**A30 Chiverton to Carland Cross
TR010026**

**8.9 RESPONSE TO HEARING ACTION
POINTS - ISH 2 ON DRAFT DCO**

April 2019

Drawing Number: **HA551502 - SW** | Originator: **ARP** | Volume: **LSI** | **-DR - ZL - 000605** | **C03**

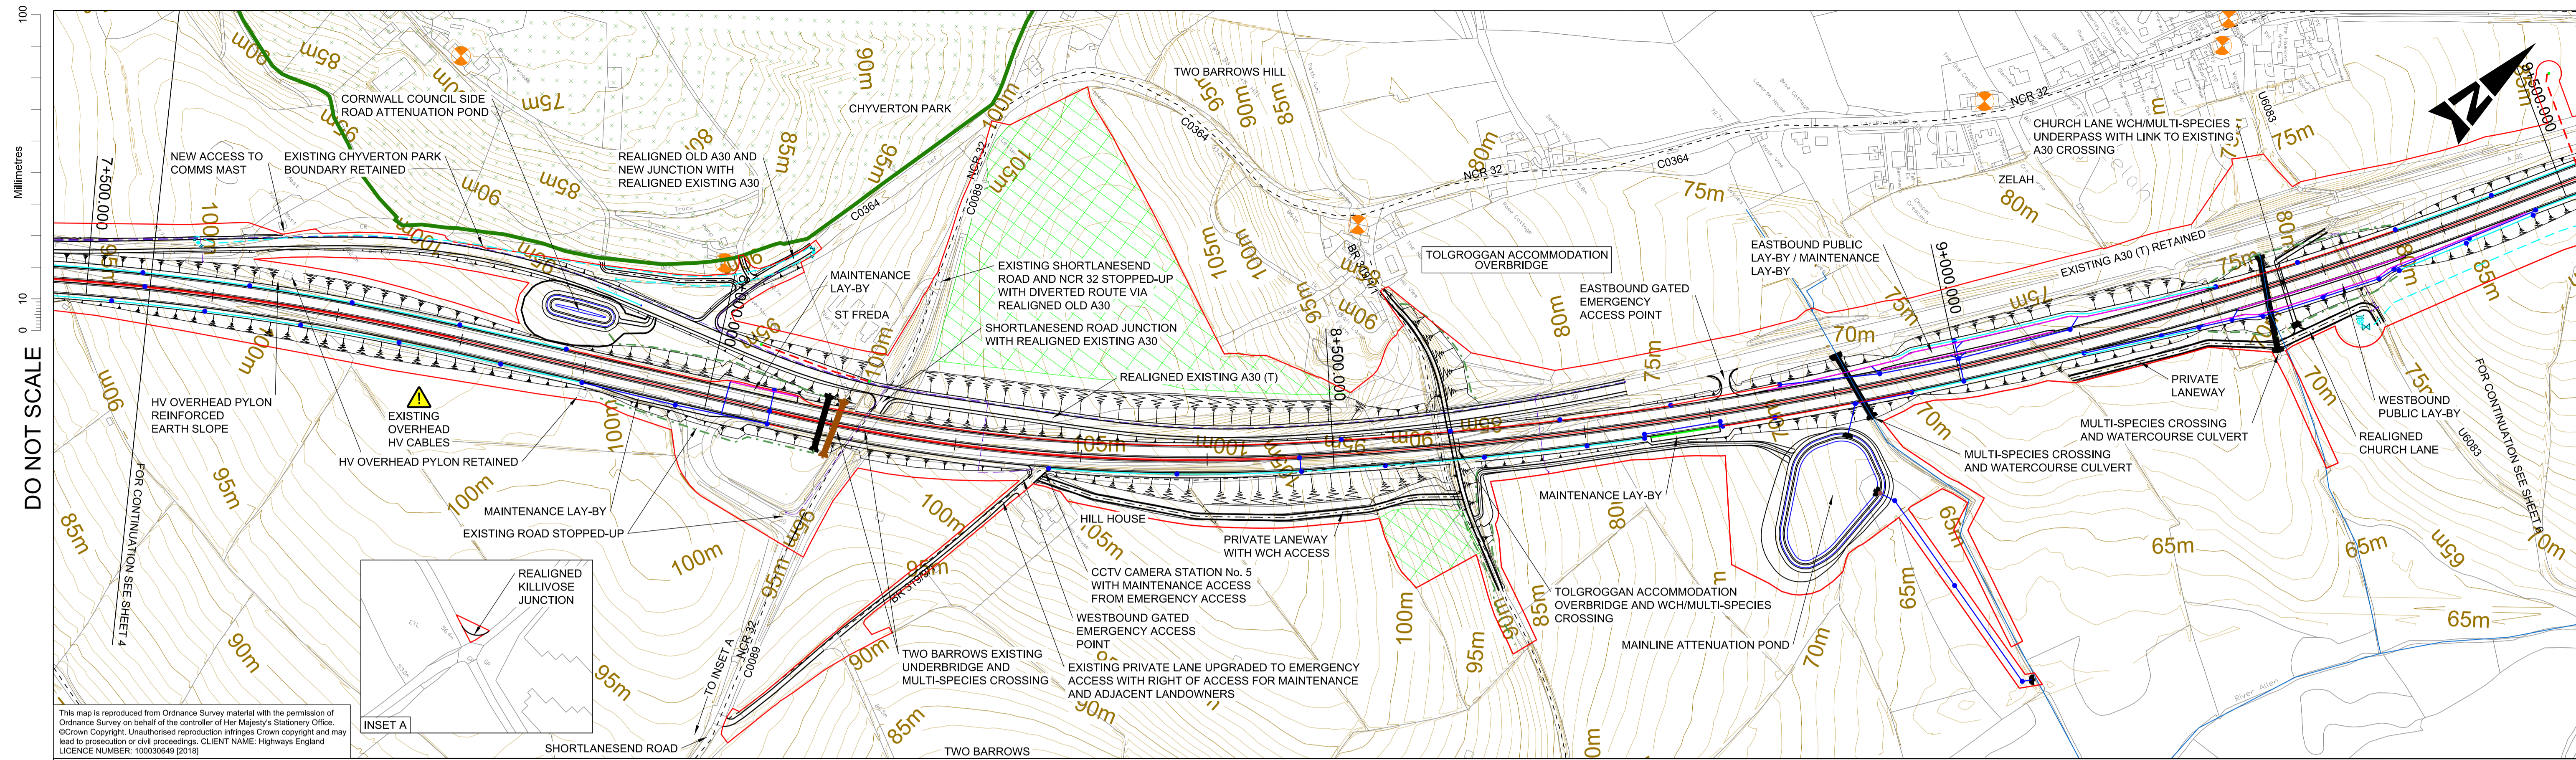
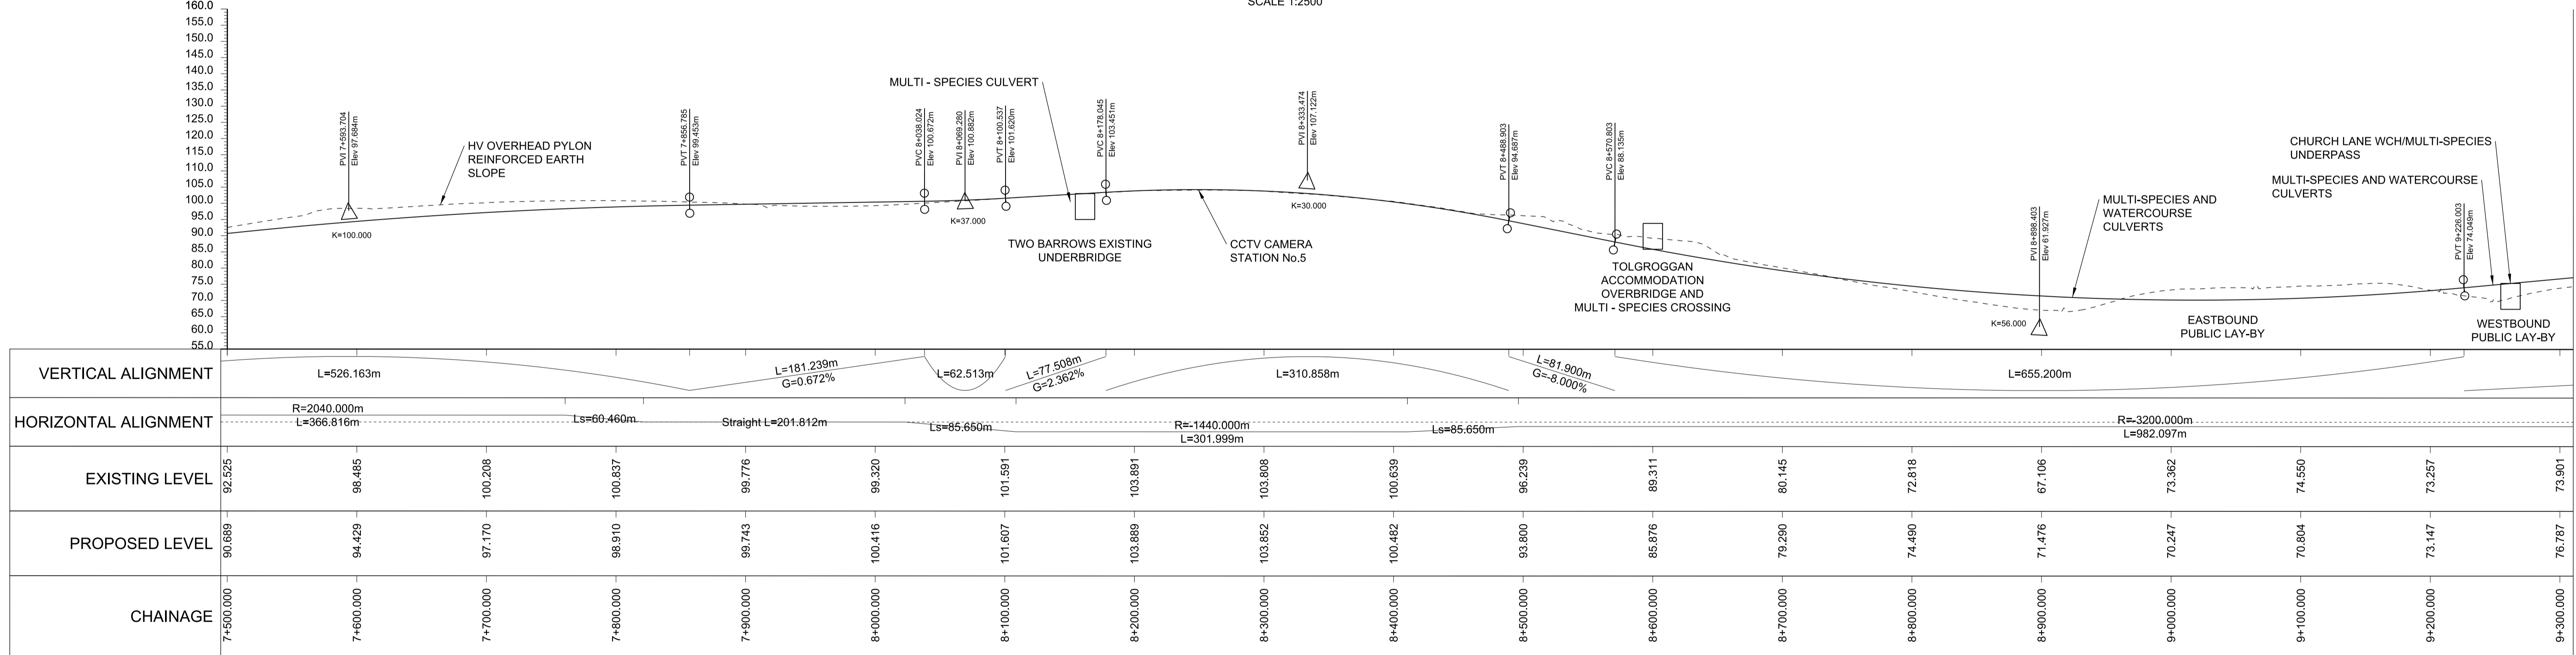
2.5(C)	Rights of Way and Access Plans, Sheet 4	Reference 27 has been added to show the 2 metre private means of access to the relocated mast.
2.6(A)	General Arrangement and Section Plans, Sheet 4	The location of the relocated mast has been added to the plan and annotated.

| Location: | Type: -DR | Role: -ZL | Number: -000608 | |

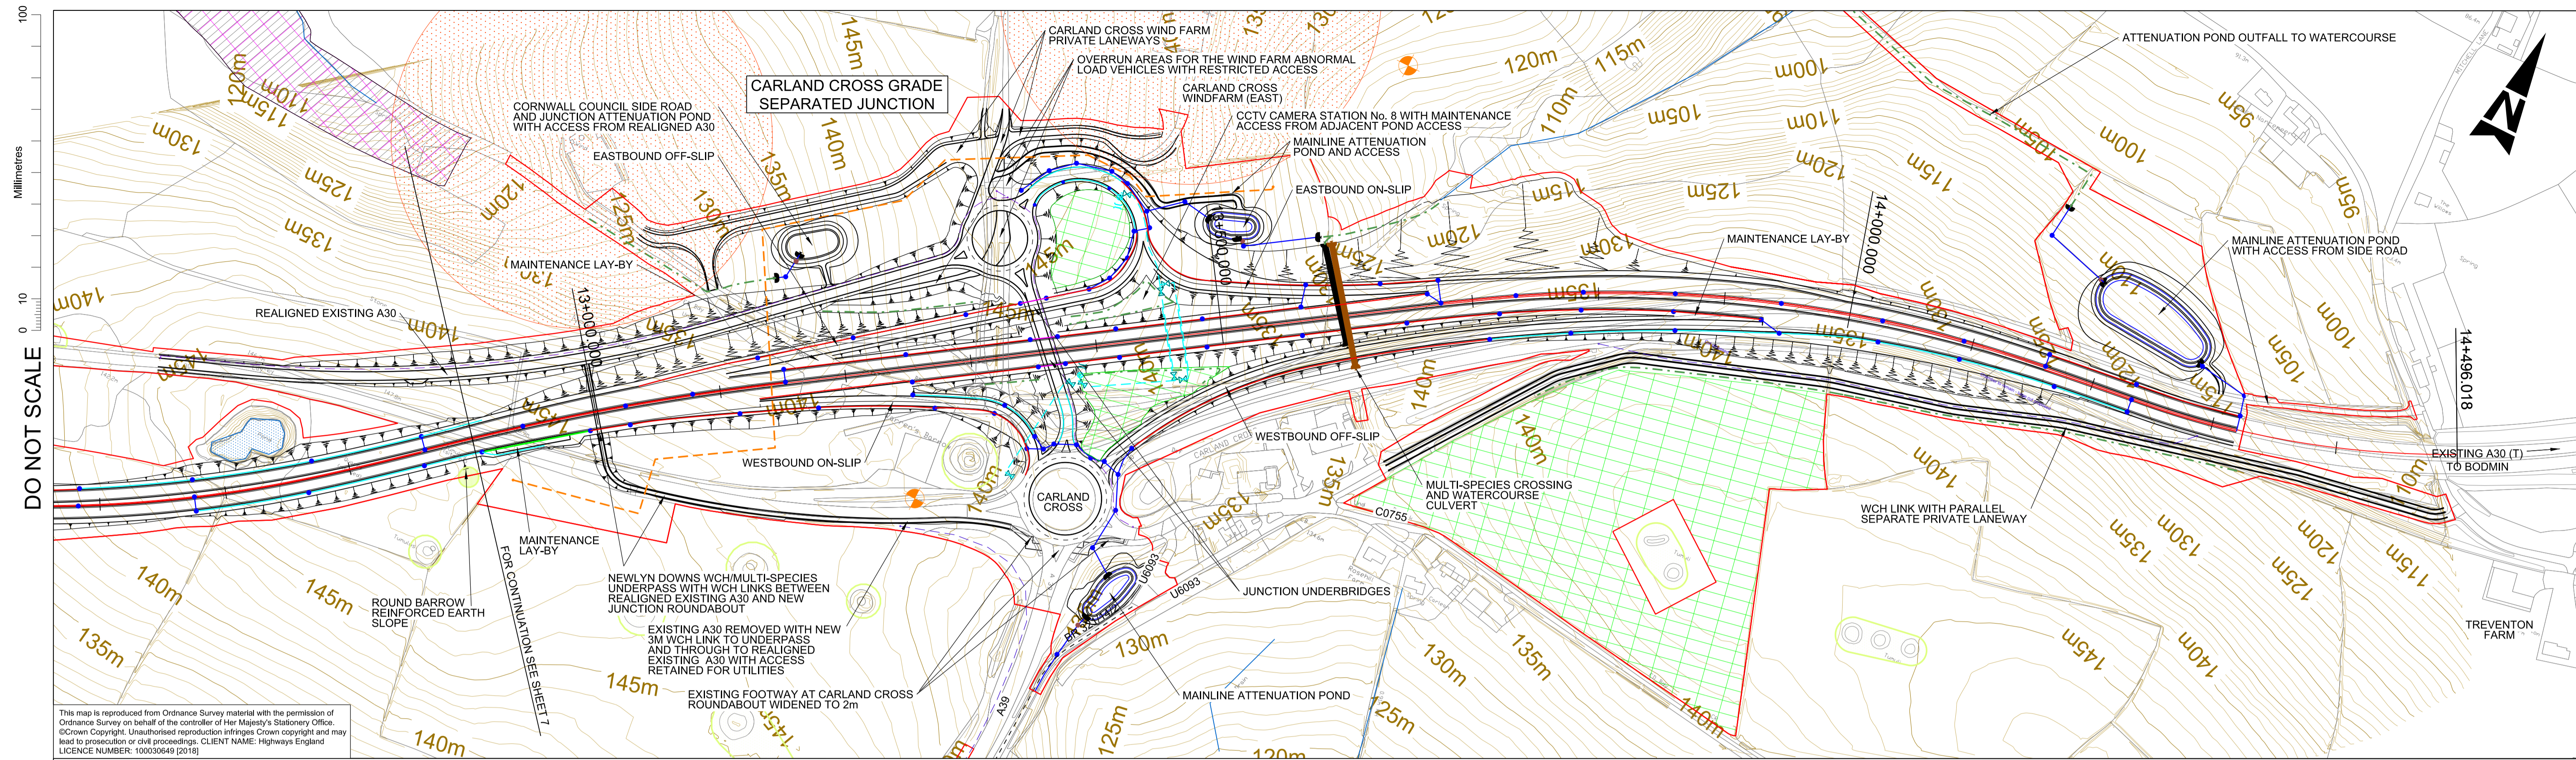
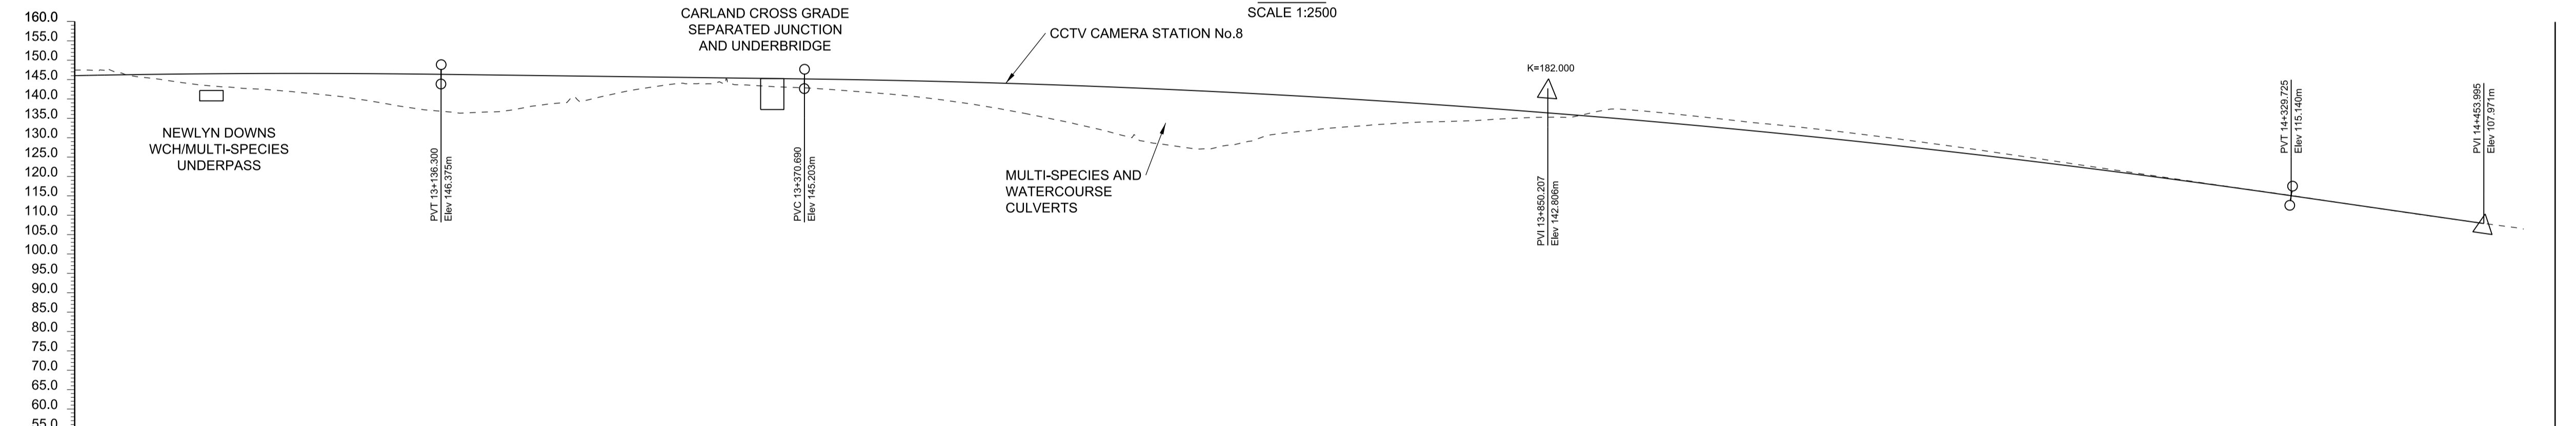
- 2.1.16 The requested amendments comprise:
- The addition of a private access lane for wind farm abnormal load vehicles only, to the south of the realigned existing A30 to join into the northern roundabout of Carland Cross as shown on Sheet 8 of the **General Arrangement and Section Plans** (Document Reference 2.6(A)).

- The addition of a private access lane across the northern roundabout of Carland Cross junction for wind farm abnormal load vehicles only, as shown on Sheet 8 of the **General Arrangement and Section Plans** (Document Reference 2.6(A)).
